RE: West Mesa Ridge Apartments
701 Coors Blvd NW
Albuquerque NM, 87121

Traffic Circulation Layout – Corrections Delta 1

TCL1.0

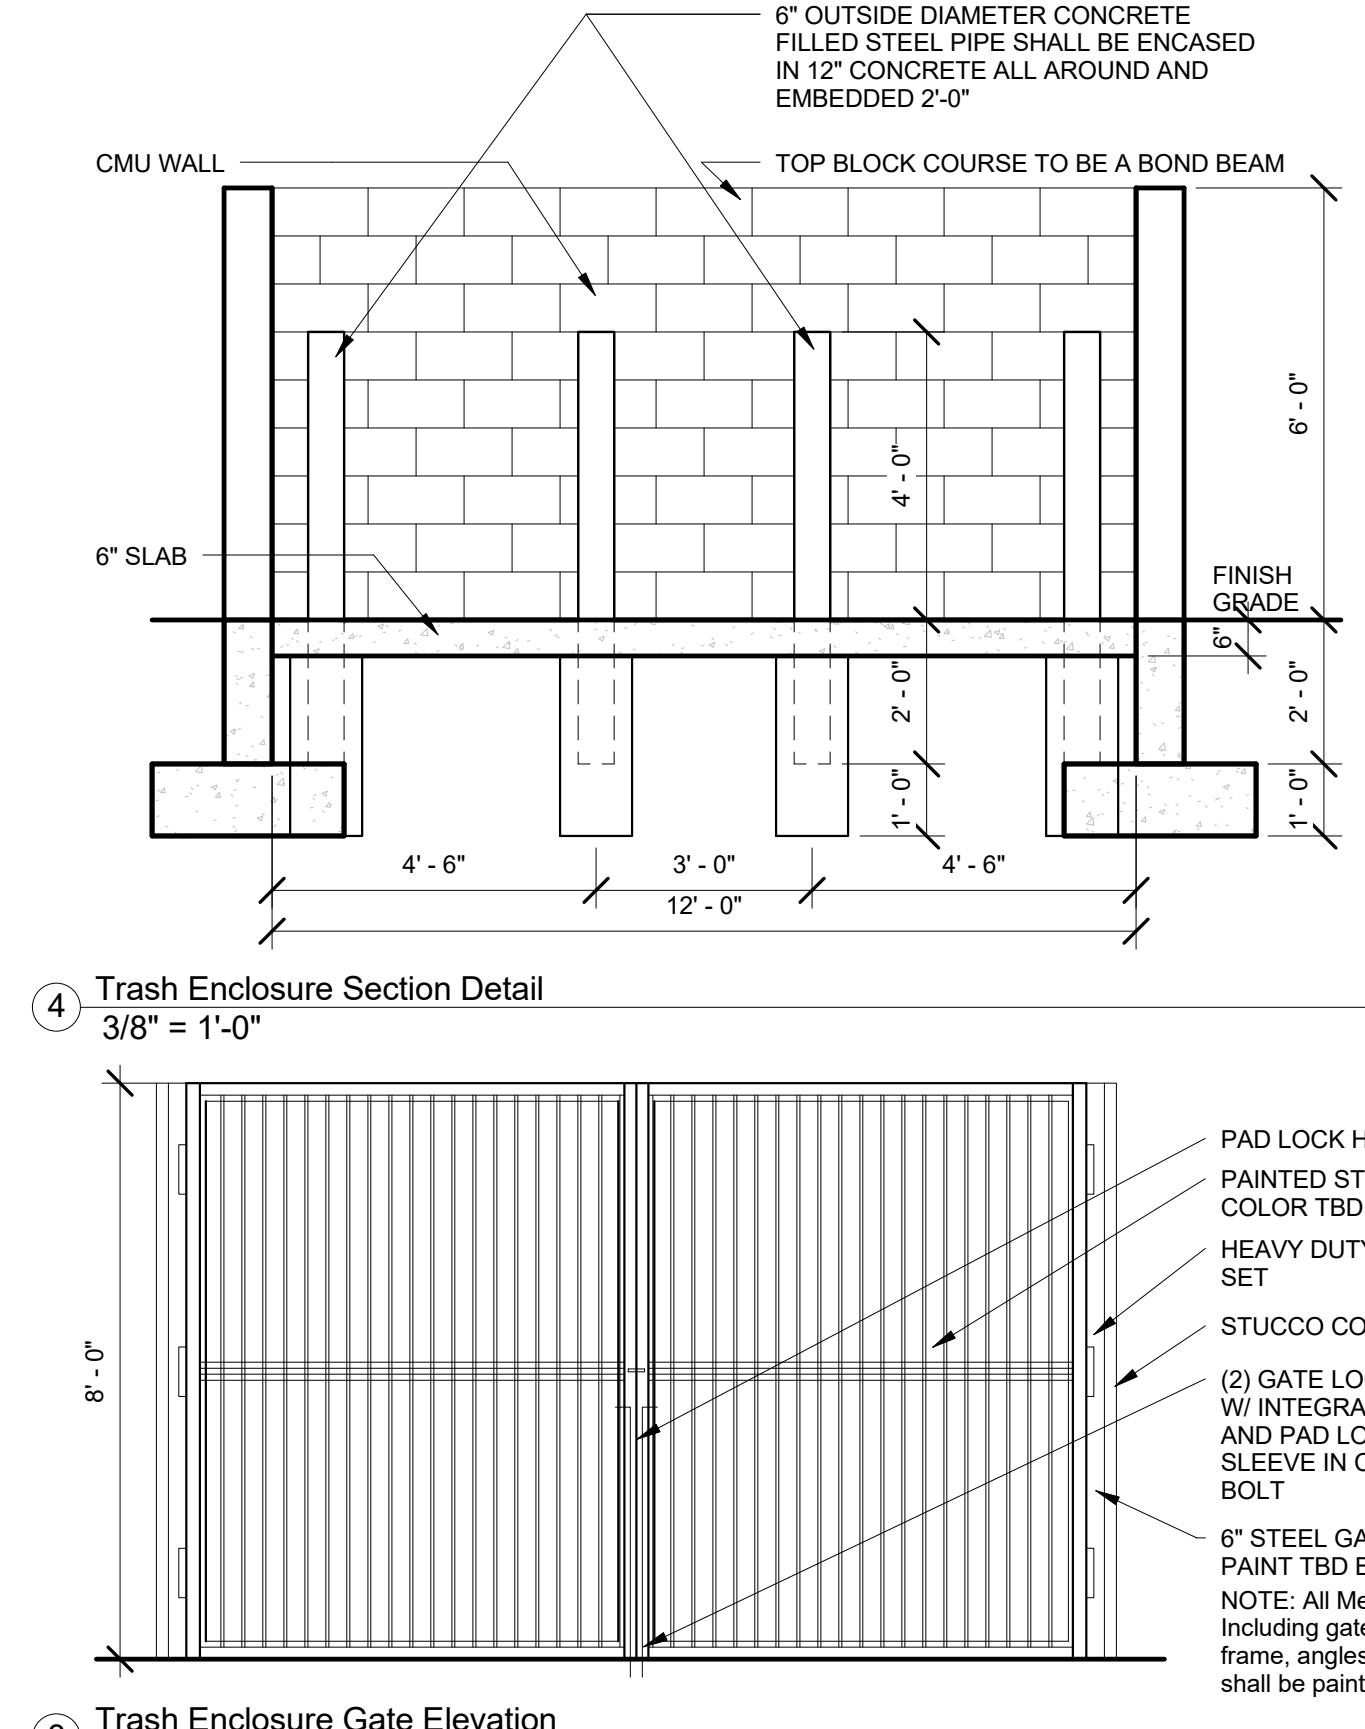
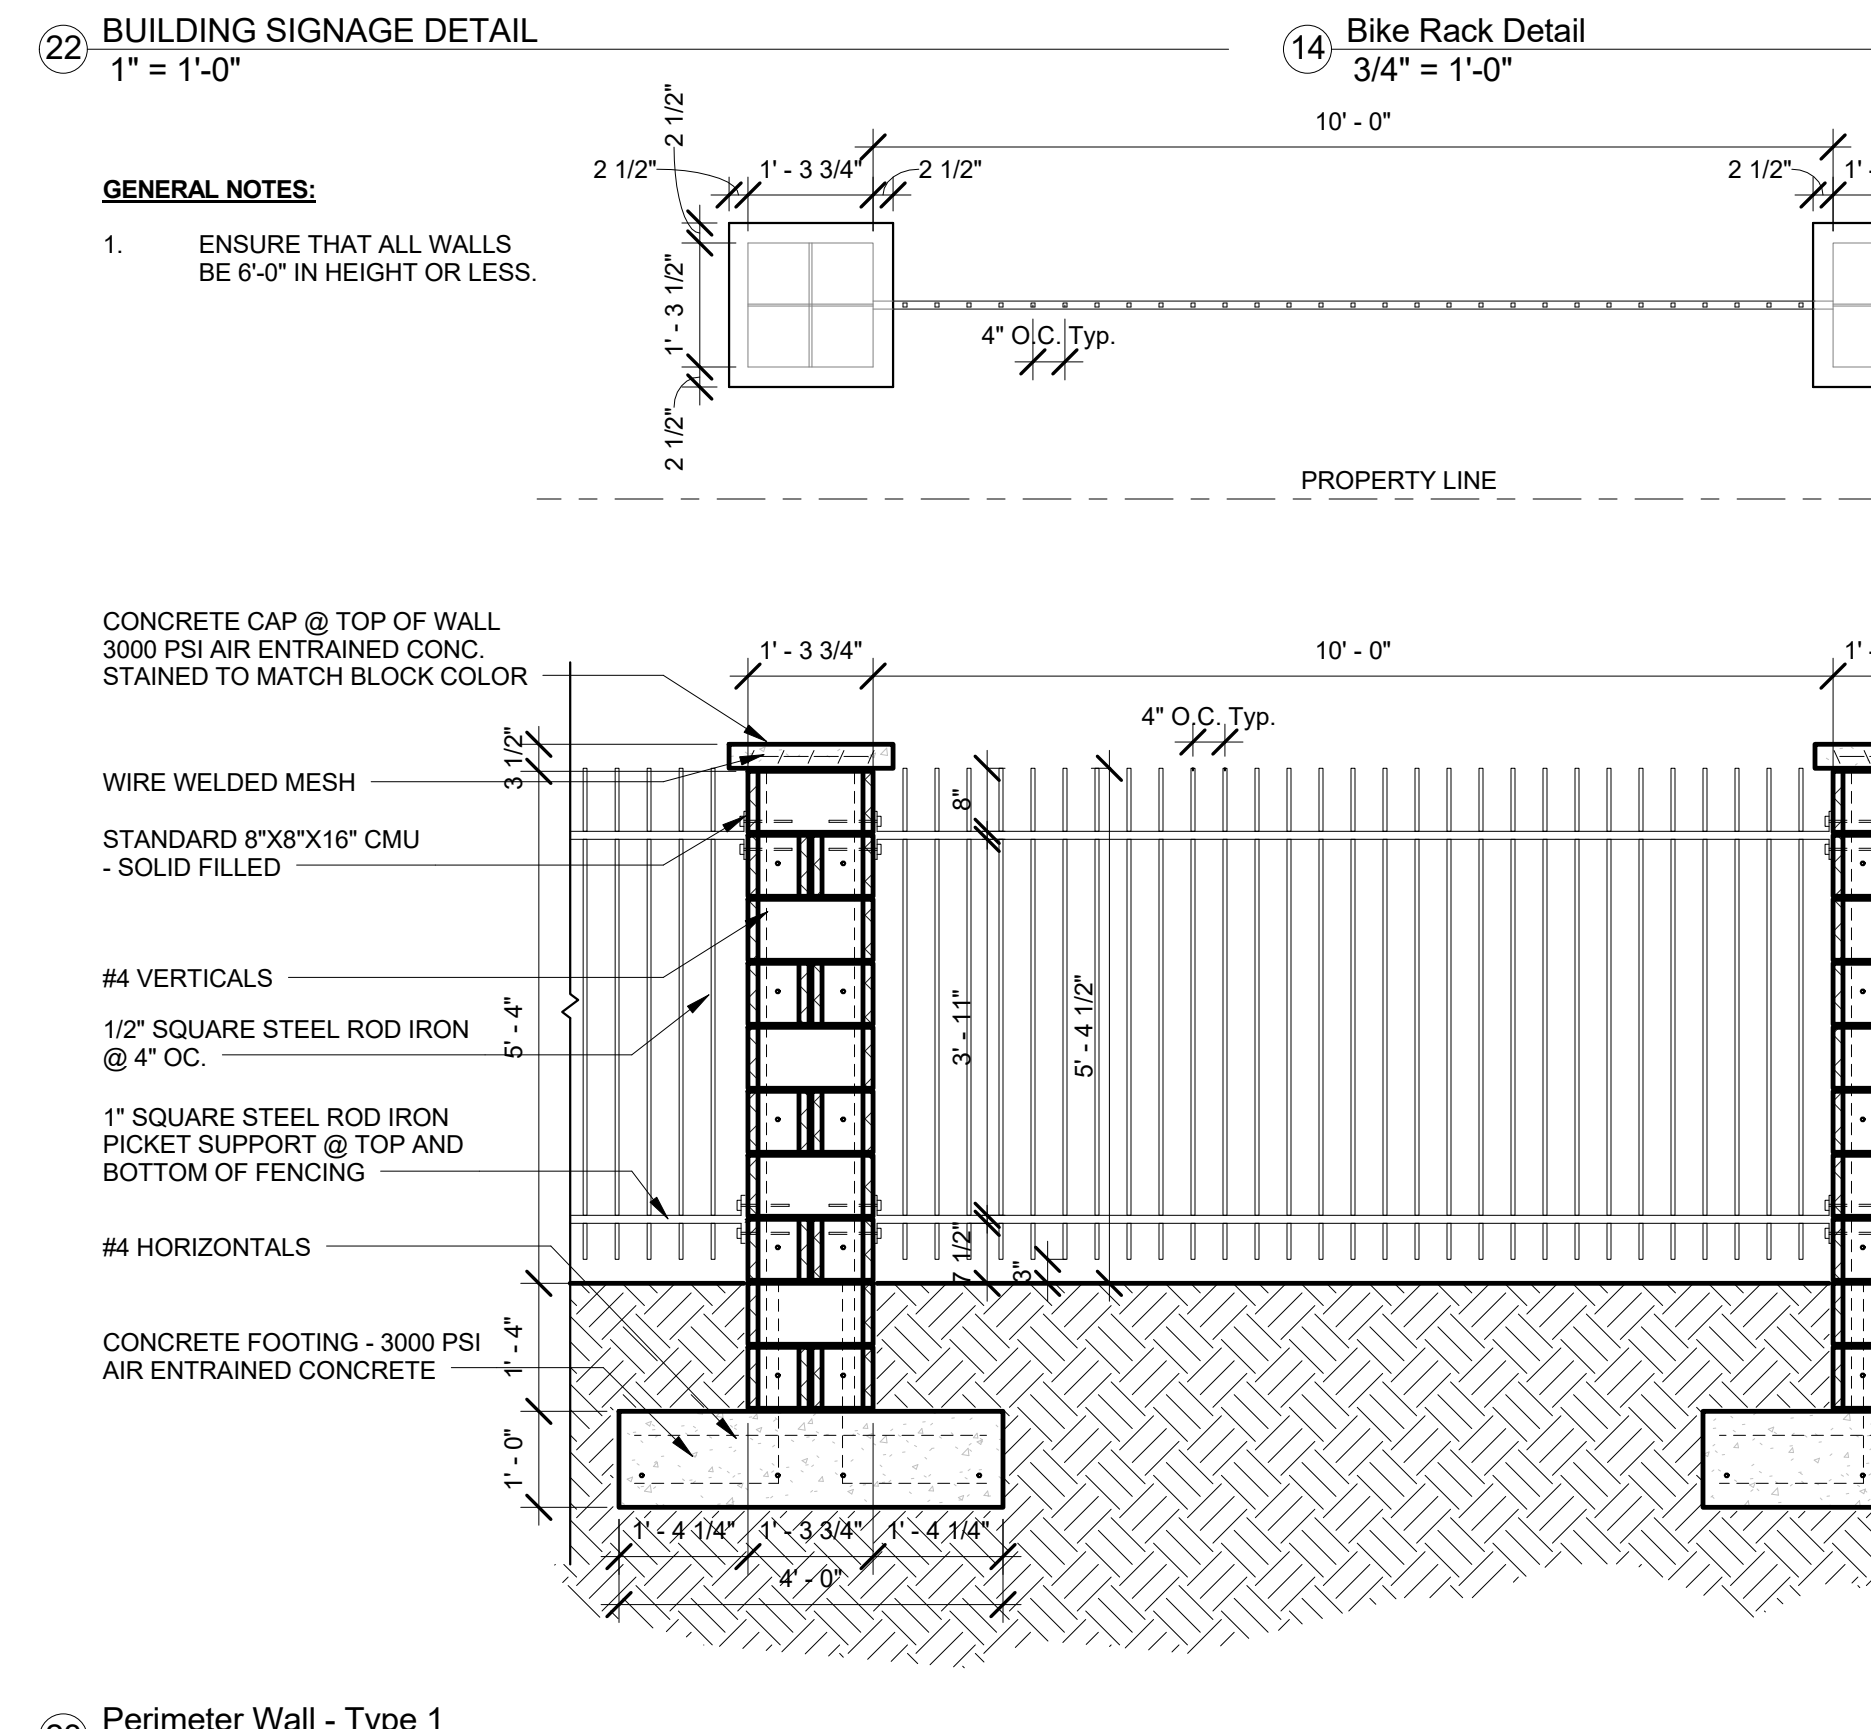
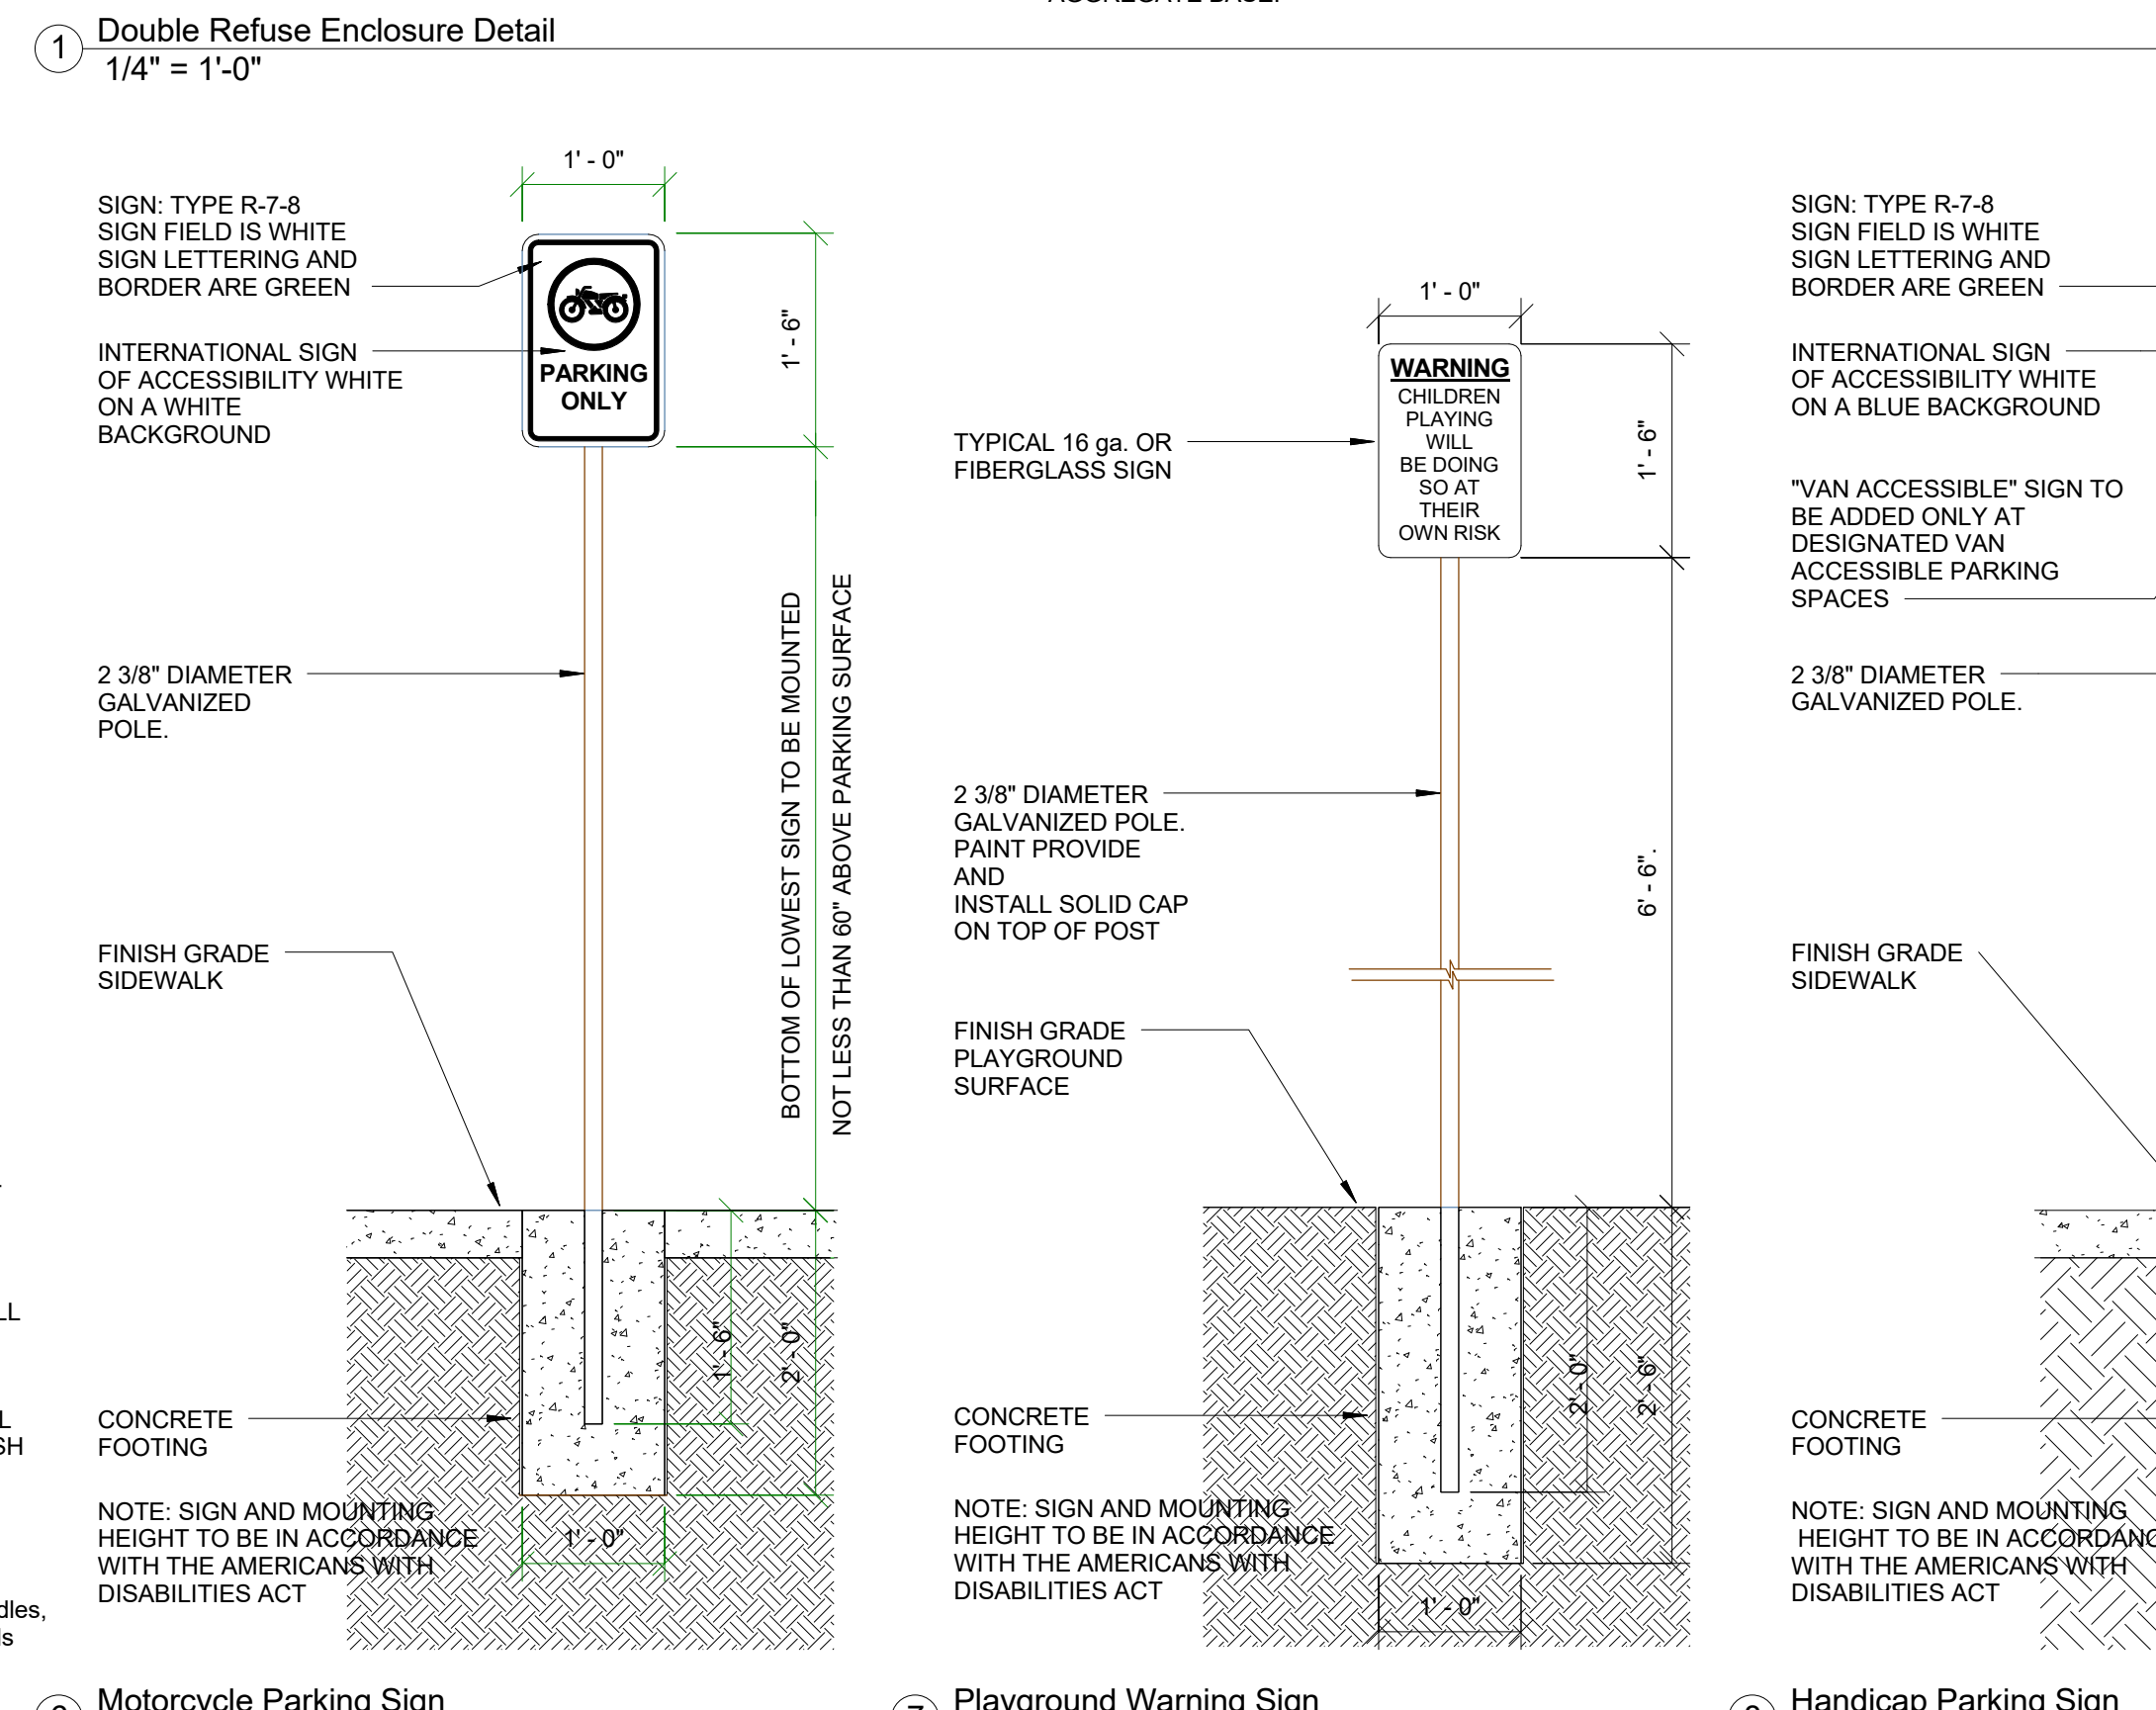
2. Show the location / details of main entrance to the facility.
A new keynote was added (39) to identify main entry into residential buildings. Keynote 15 was edited to show main entry into community building.

5. Provide the hatch legends
A hatch legend showing concrete and clear sight triangle has been added to the updated TCL.
6. Show the number of spots for motorcycle parking and bike racks required by IDO in the plan.
I updated the parking count to include motorcycle and bicycle parking spaces. Please see keynote 13 and 35.

12. Show all drive aisle widths and radii. Some dimensions are not shown.
The updated TCL now shows aisle widths, sidewalk widths, and radii throughout.

14. List radii for all curves shown; for passenger vehicles. Radius for delivery trucks, fire trucks, ect. Is 25 ft or larger.
The attached TCL has been updated to show radii for curves throughout the site. The roundabout radius exceeds the minimum requirements per the table that was shared on the original TCL Comment Document.
